**Application by Highways England for the M25 Junction 28 improvement scheme (the Proposed Development)**  
**The Examining Authority's Written Questions and Requests for information (WQ1)**  
**Issued on Wednesday 13 January 2021**

**Responses are due by Deadline 2: Thursday 4 February 2021**

Project Title	M25 Junction 28		
Drawing Title	FIGURE 5.1 AIR QUALITY CONSTRAINTS		
Drawing Number	Project	Originator	Volume
	HE551519 - ATK - EAQ	XX - GS - GI - 000001	
Original Size: A3	Scale: 1:25,000	Project Ref. No: --	Sheet: 1 of 1 Rev: C03

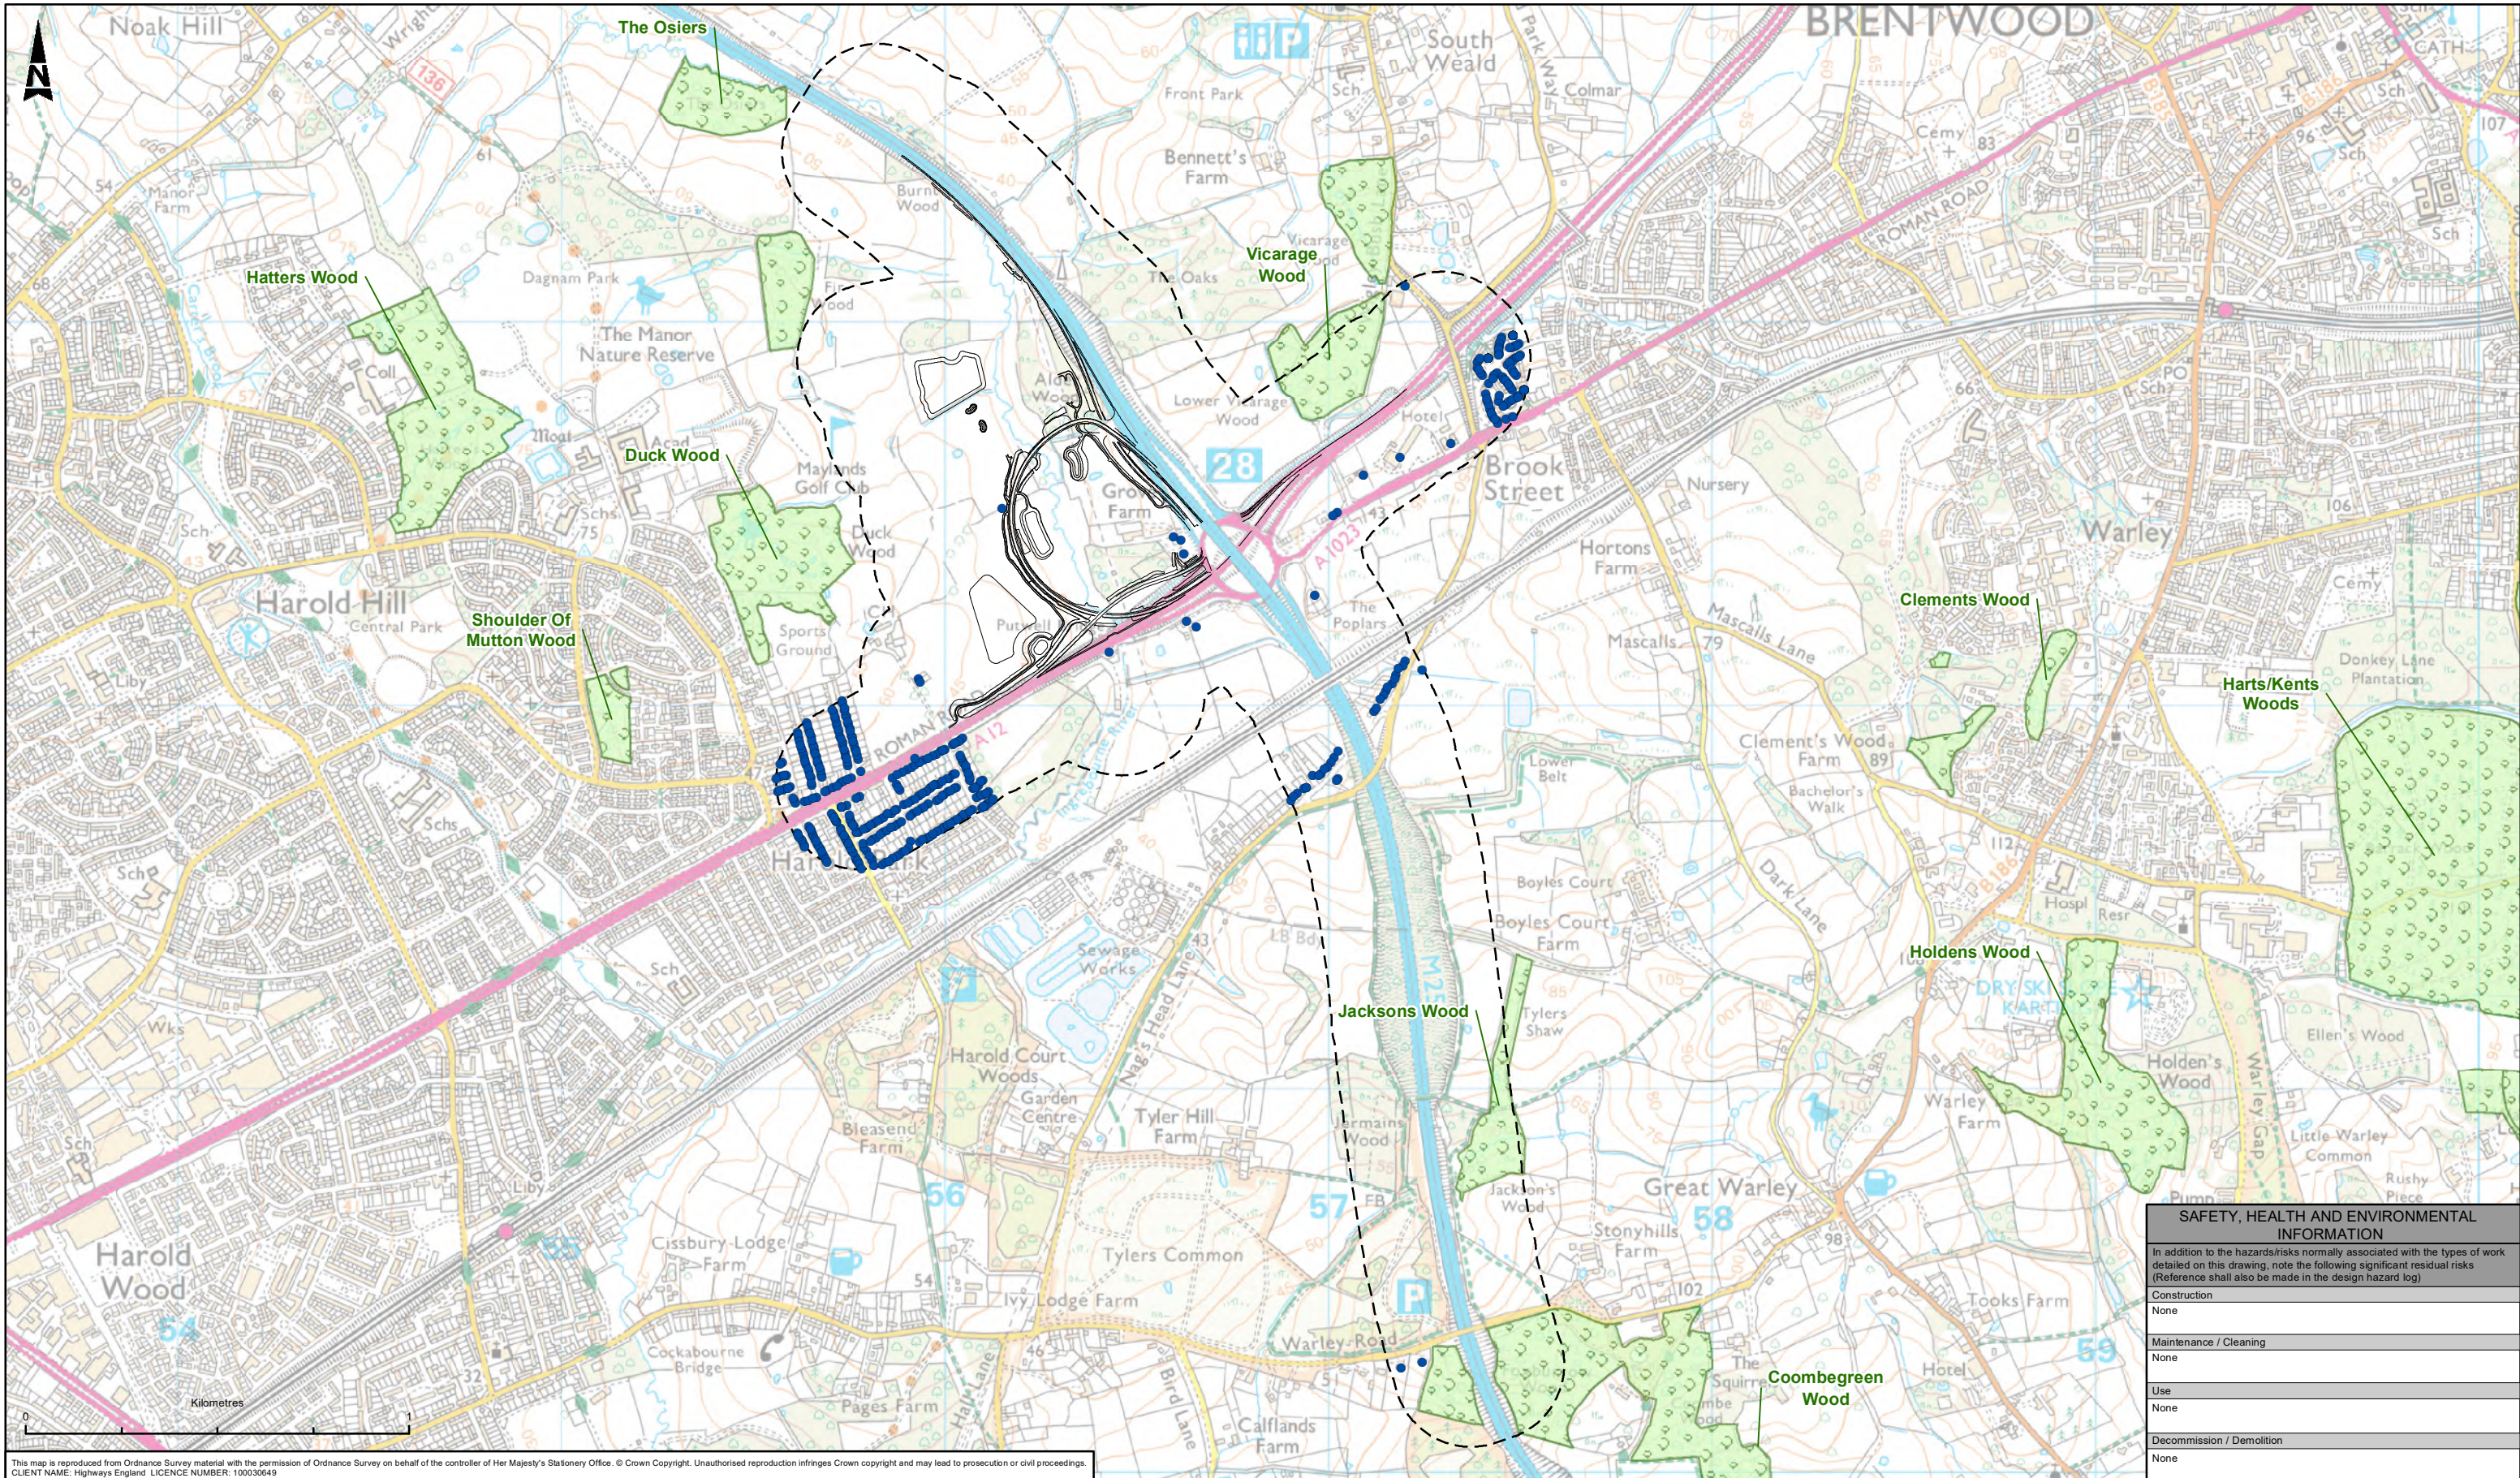
AQ 1.6	<p><i>Methodology</i> <b>The Applicant</b></p>	<p>Air quality modelling has been undertaken based on IAN 170/12 v3 and is detailed in Appendix 5.1 [APP-052]. The Applicant has not explained why the monitoring stations shown on Figure 5.1 [APP-040], especially those within the Brentwood Air Quality Management Area (AQMA) which are exceeding the nitrogen dioxide (NO<sub>2</sub>) 40ug/m<sup>3</sup> (micrograms per cubic metre) limit have not been modelled for the 2022 operation year.</p> <p>Explain why the air quality monitoring stations shown on Figure 5.1 have not been included within the air quality model for the operation year of 2022, considering these receptors are within the Havering and Brentwood AQMA's.</p>
AQ 1.7	<p><i>Methodology</i></p>	<p>Paragraph 5.7.25 of Chapter 5 of the ES [APP-027] states that Maylands Golf Club will be included as a receptor, and Maylands Golf Club is stated to be receptor R79 in Table</p>

Project Title	M25 Junction 28
Drawing Title	FIGURE 5.2 STUDY AREA FOR CONSTRUCTION DUST ASSESSMENT
Drawing Number	HE551519 - ATK - EAQ XX - GS - GI - 000002
Original Size	A3
Scale	1:16,000
Project Ref. No.	---
Sheet	1 of 1
Rev.	C03

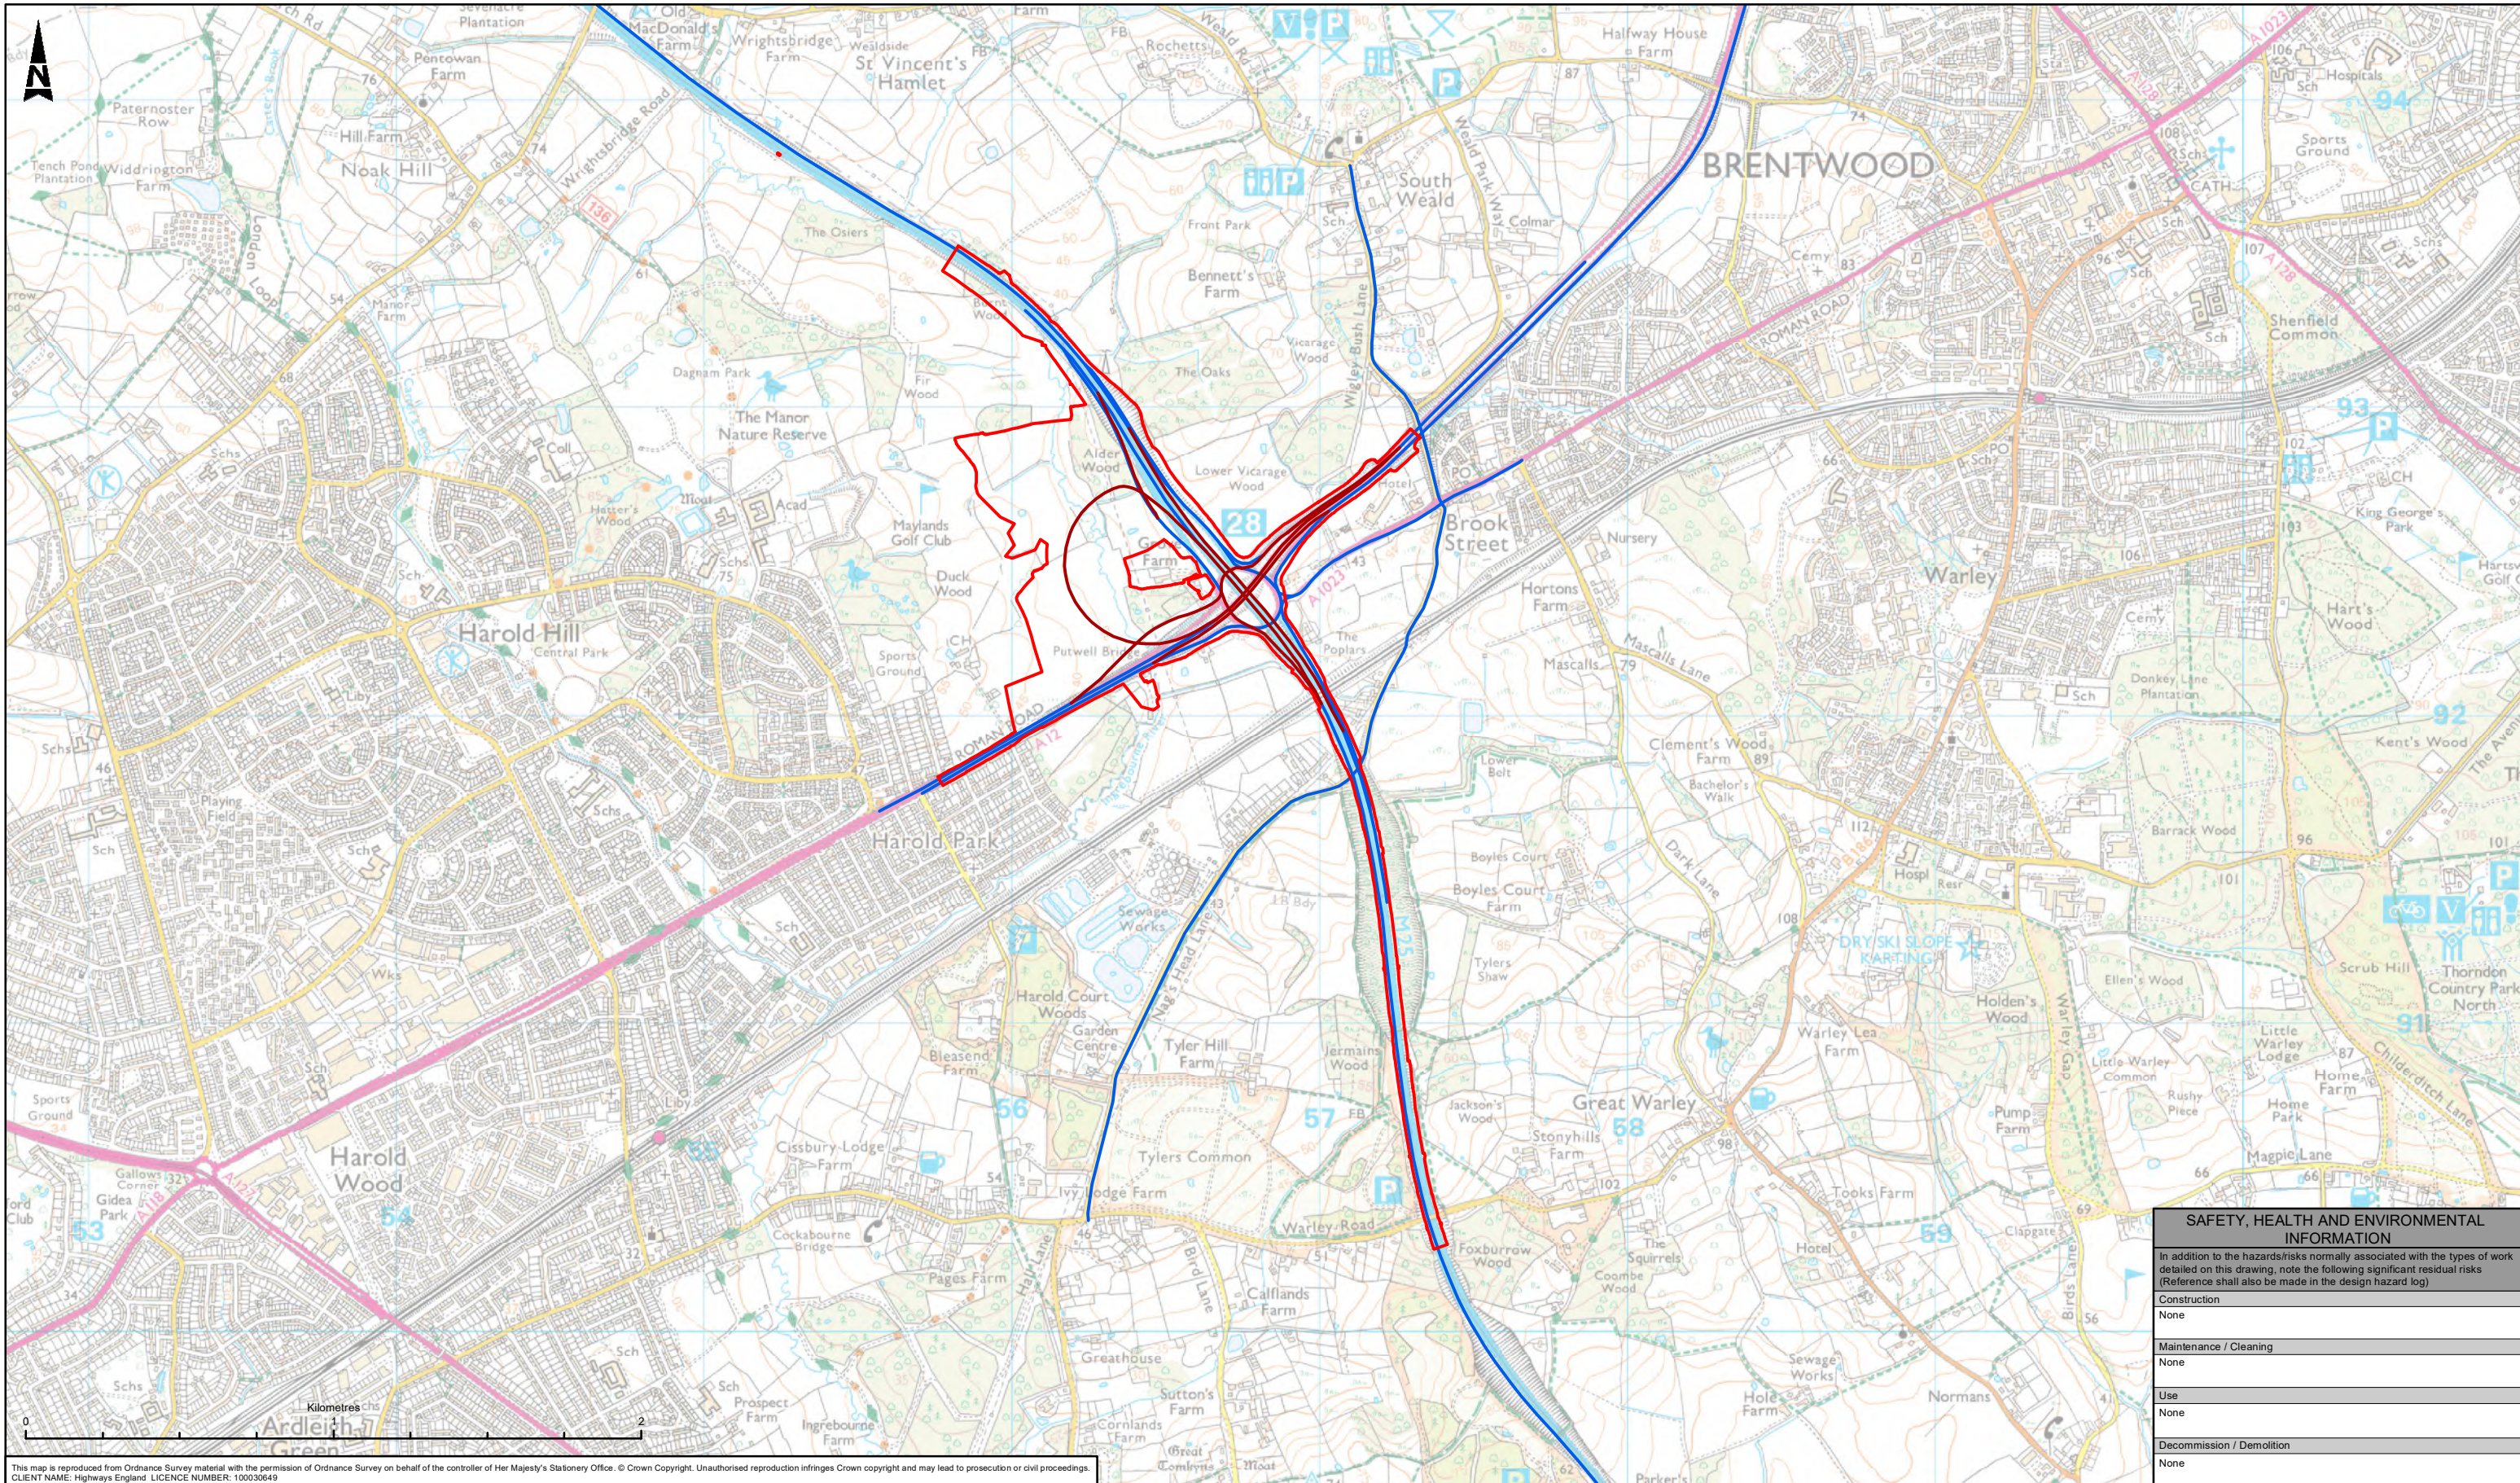
AQ	Air Quality	
AQ 1.1	<i>Baseline Assessment</i> <b>The Applicant</b>	<p>Figure 5.2 of the Air Quality Figures accompanying Chapter 5 of the ES [APP-040] presents receptors sensitive to construction dust and highlights the ancient woodland surrounding the site. However, some of the highlighted ancient woodlands are outside of the construction dust study area so it is unclear if these are included as receptors or not. Furthermore, Figure 5.2 does not illustrate other ecological receptors, such as Local Nature Reserves (LNR) and Local Wildlife Sites (LWS) that are within the study area. These receptors are shown on Figure 7.3 [APP-042].</p> <p>In addition to information provided within Chapter 5 of the ES [APP-027], clarify where receptors sensitive to construction dust and other ecological receptors that have been assessed are with respect to the Proposed Development, provide a figure that contains the following:</p> <ul style="list-style-type: none"><li>- The Order limits.</li><li>- The construction and dust air quality assessment study areas.</li><li>- Relevant sensitive human and ecological receptors.</li></ul>
